G-5776

Subject: Plan Review & Minimum Risk Statement
Proposed New Deck and Stairs
9405 SE 47th St
Mercer Island, Washington

**Ref: "Geotechnical Engineering Investigation, Proposed New Deck and Stairs
9405 SE 47th St Mercer Island, Washington, GEO Group Northwest, October
13th, 2022."**

1 SITEPLAN
1" = 20'-0"

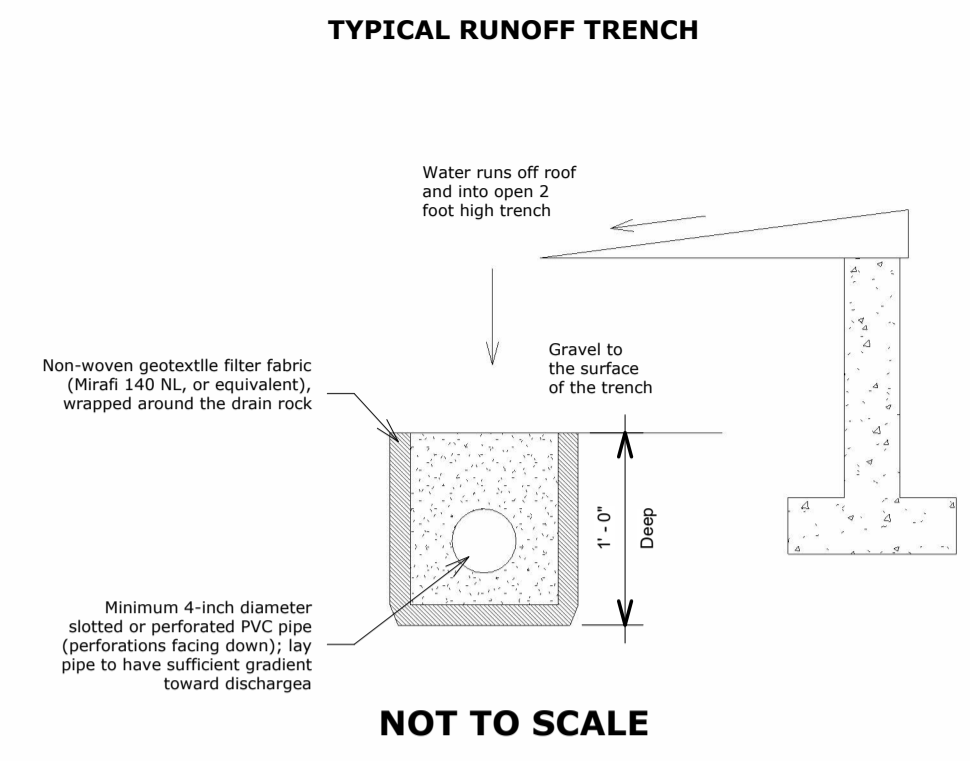
In our opinion, the reviewed plans are consistent with the geotechnical recommendations presented in the above referenced geotechnical report. The recommended runoff trench is shown correctly per geotechnical recommendations. Provided that the recommendations in these documents are properly implemented, it is our opinion the proposed development will not increase the potential for soil movement, and the risk of damage to the site or from the site to adjacent properties from soil instability will be minimal. Minimum risk does not mean no risk,
